May 22, 2013

RE: Zentz Short Plat SP-13-00003

Joe Gilbert  
Environmental Health Specialist II  
Kittitas County Public Health Department

**ZENTZ SHORT PLAT**  
**KITTITAS COUNTY SHORT PLAT NO. SP-13-**  
 A PORTION OF THE NW 1/4 OF SECTION 20, TOWNSHIP 18 NORTH, RANGE 18 EAST, W.M.,  
 KITTITAS COUNTY, WASHINGTON

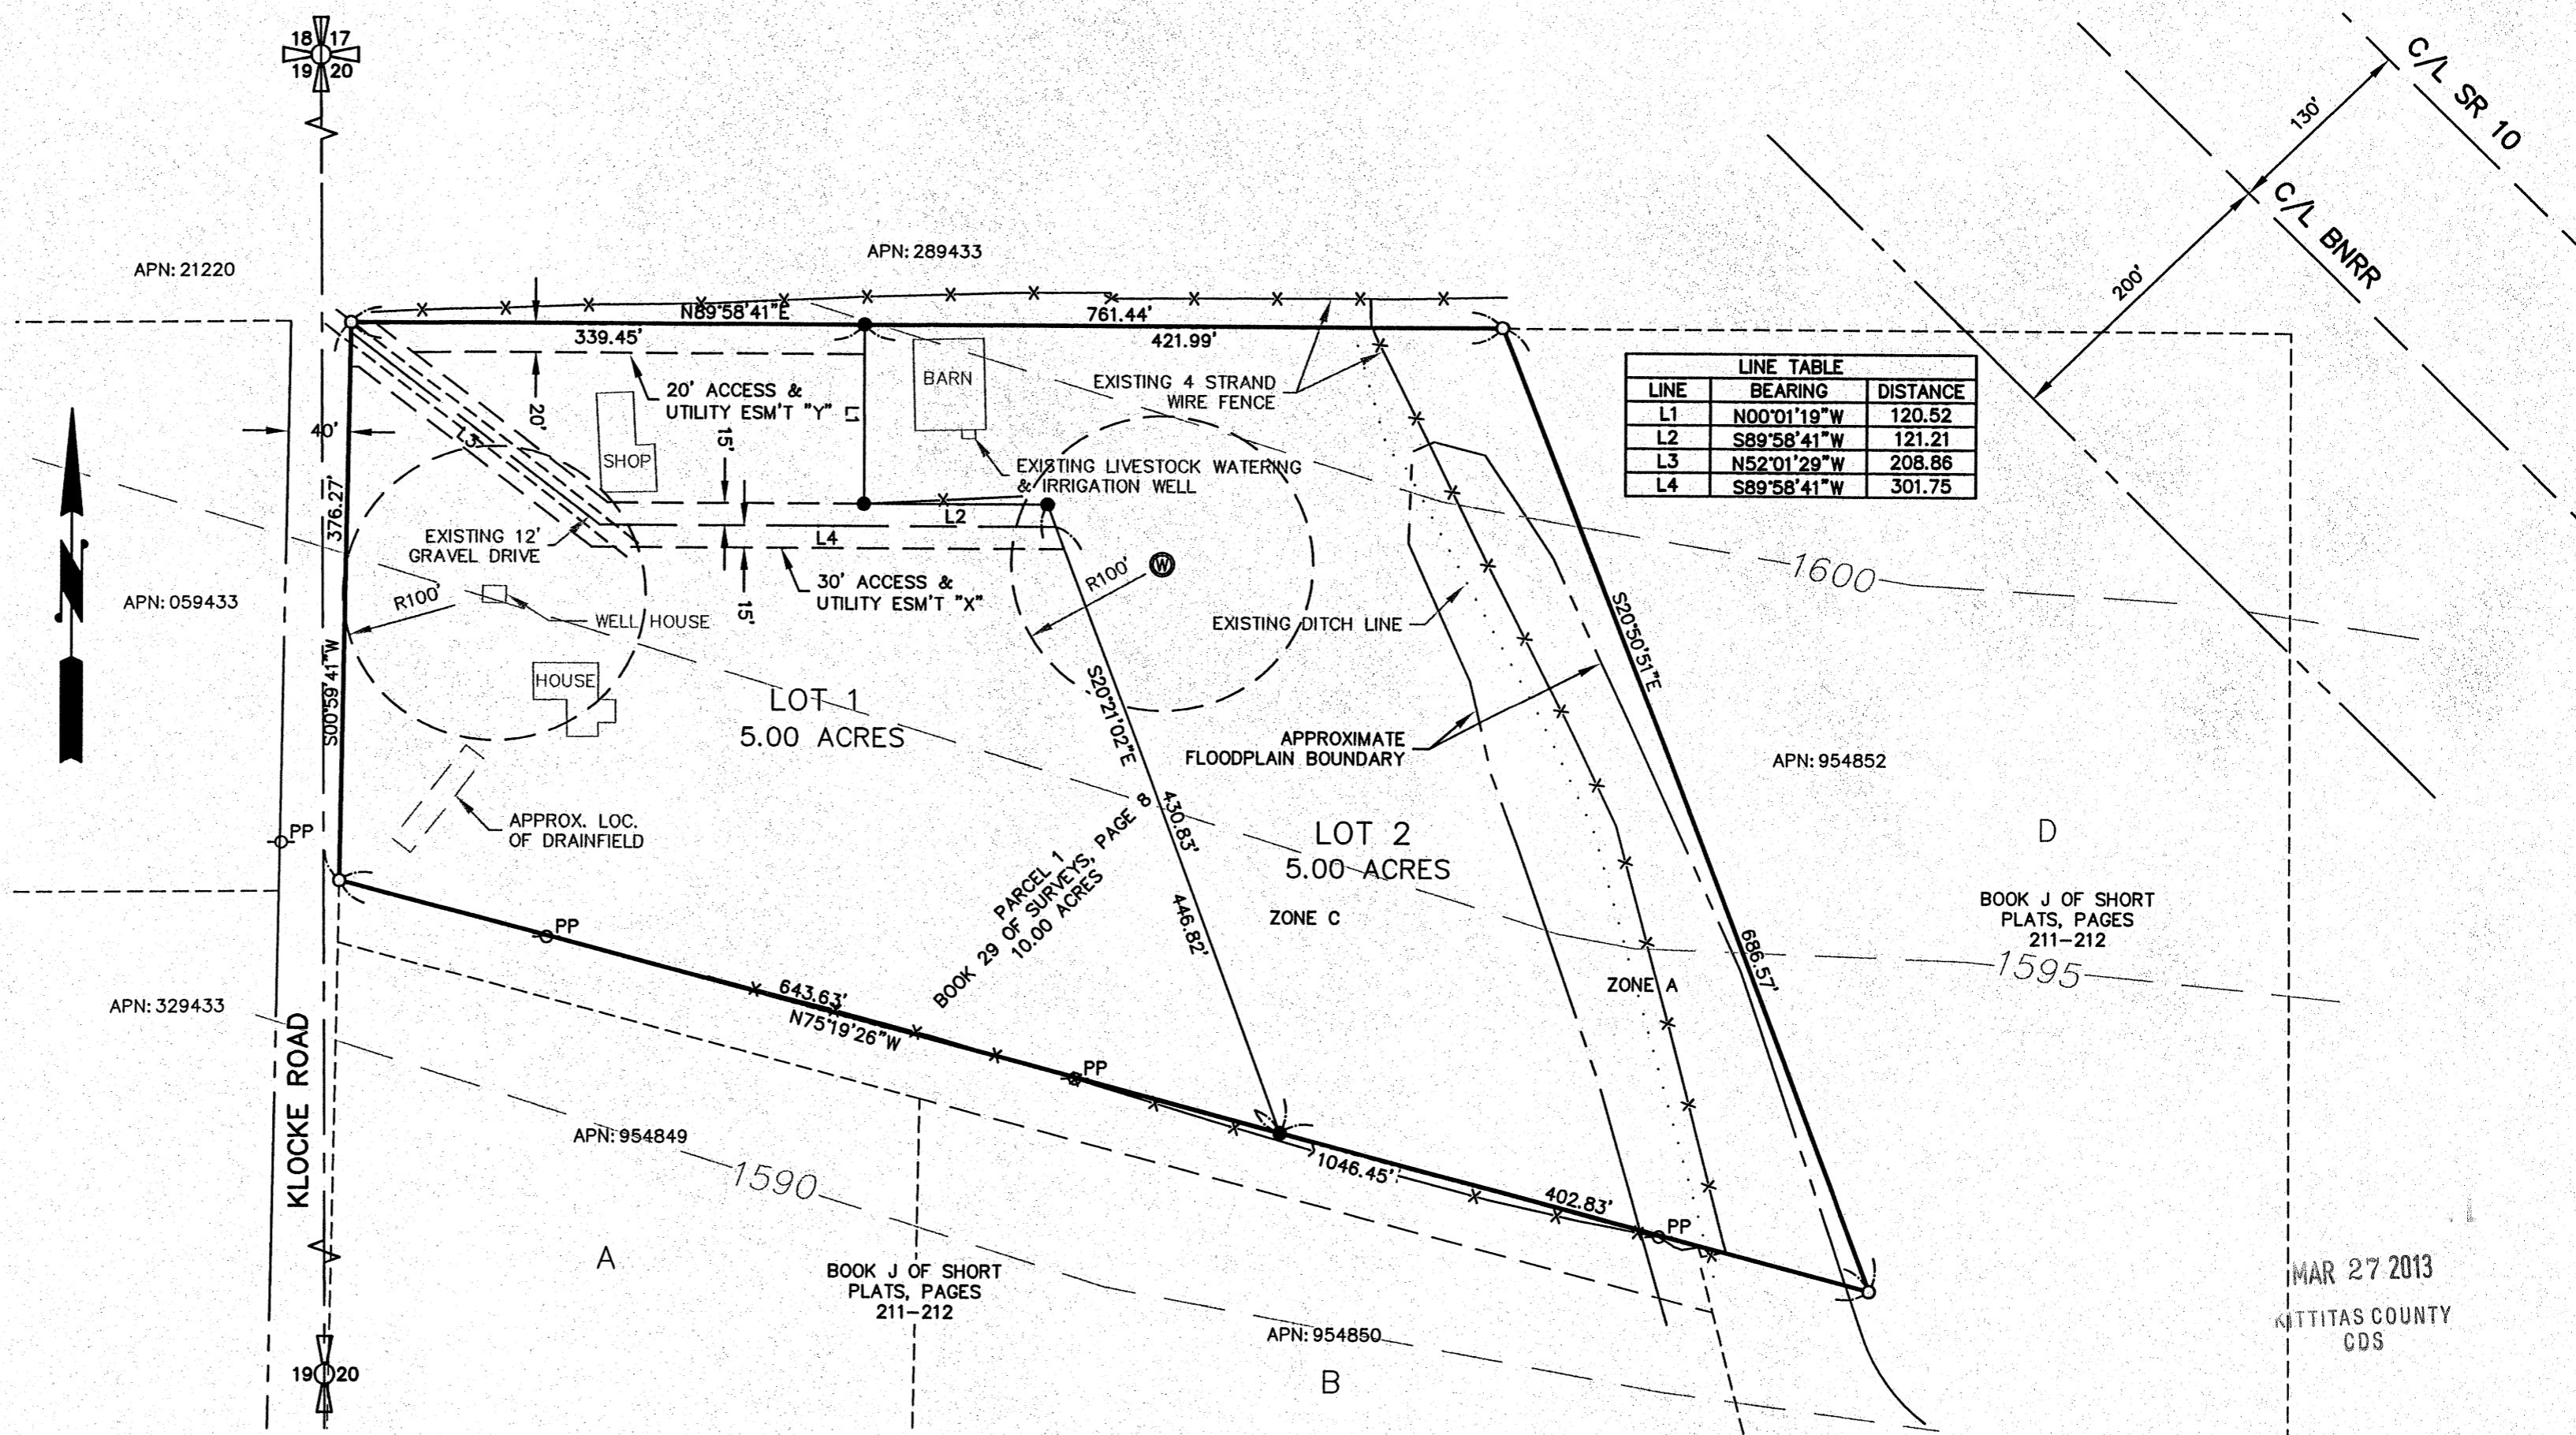
**REVIEW OF THE APPLICATION FILE:** Soil logs have been satisfied for this proposed short plat, a site evaluation was performed in 2012 and a revisit of new soil logs in 2013. It appears that both lots have wells, however, the well on lot 2 is described as a livestock and irrigation well. Either this well will need to be approved by Dept. of Ecology as a domestic water well, or an additional well will need to be

drilled. Another option would be to share the well on lot 1, a shared well users agreement would need to be recorded and filed.
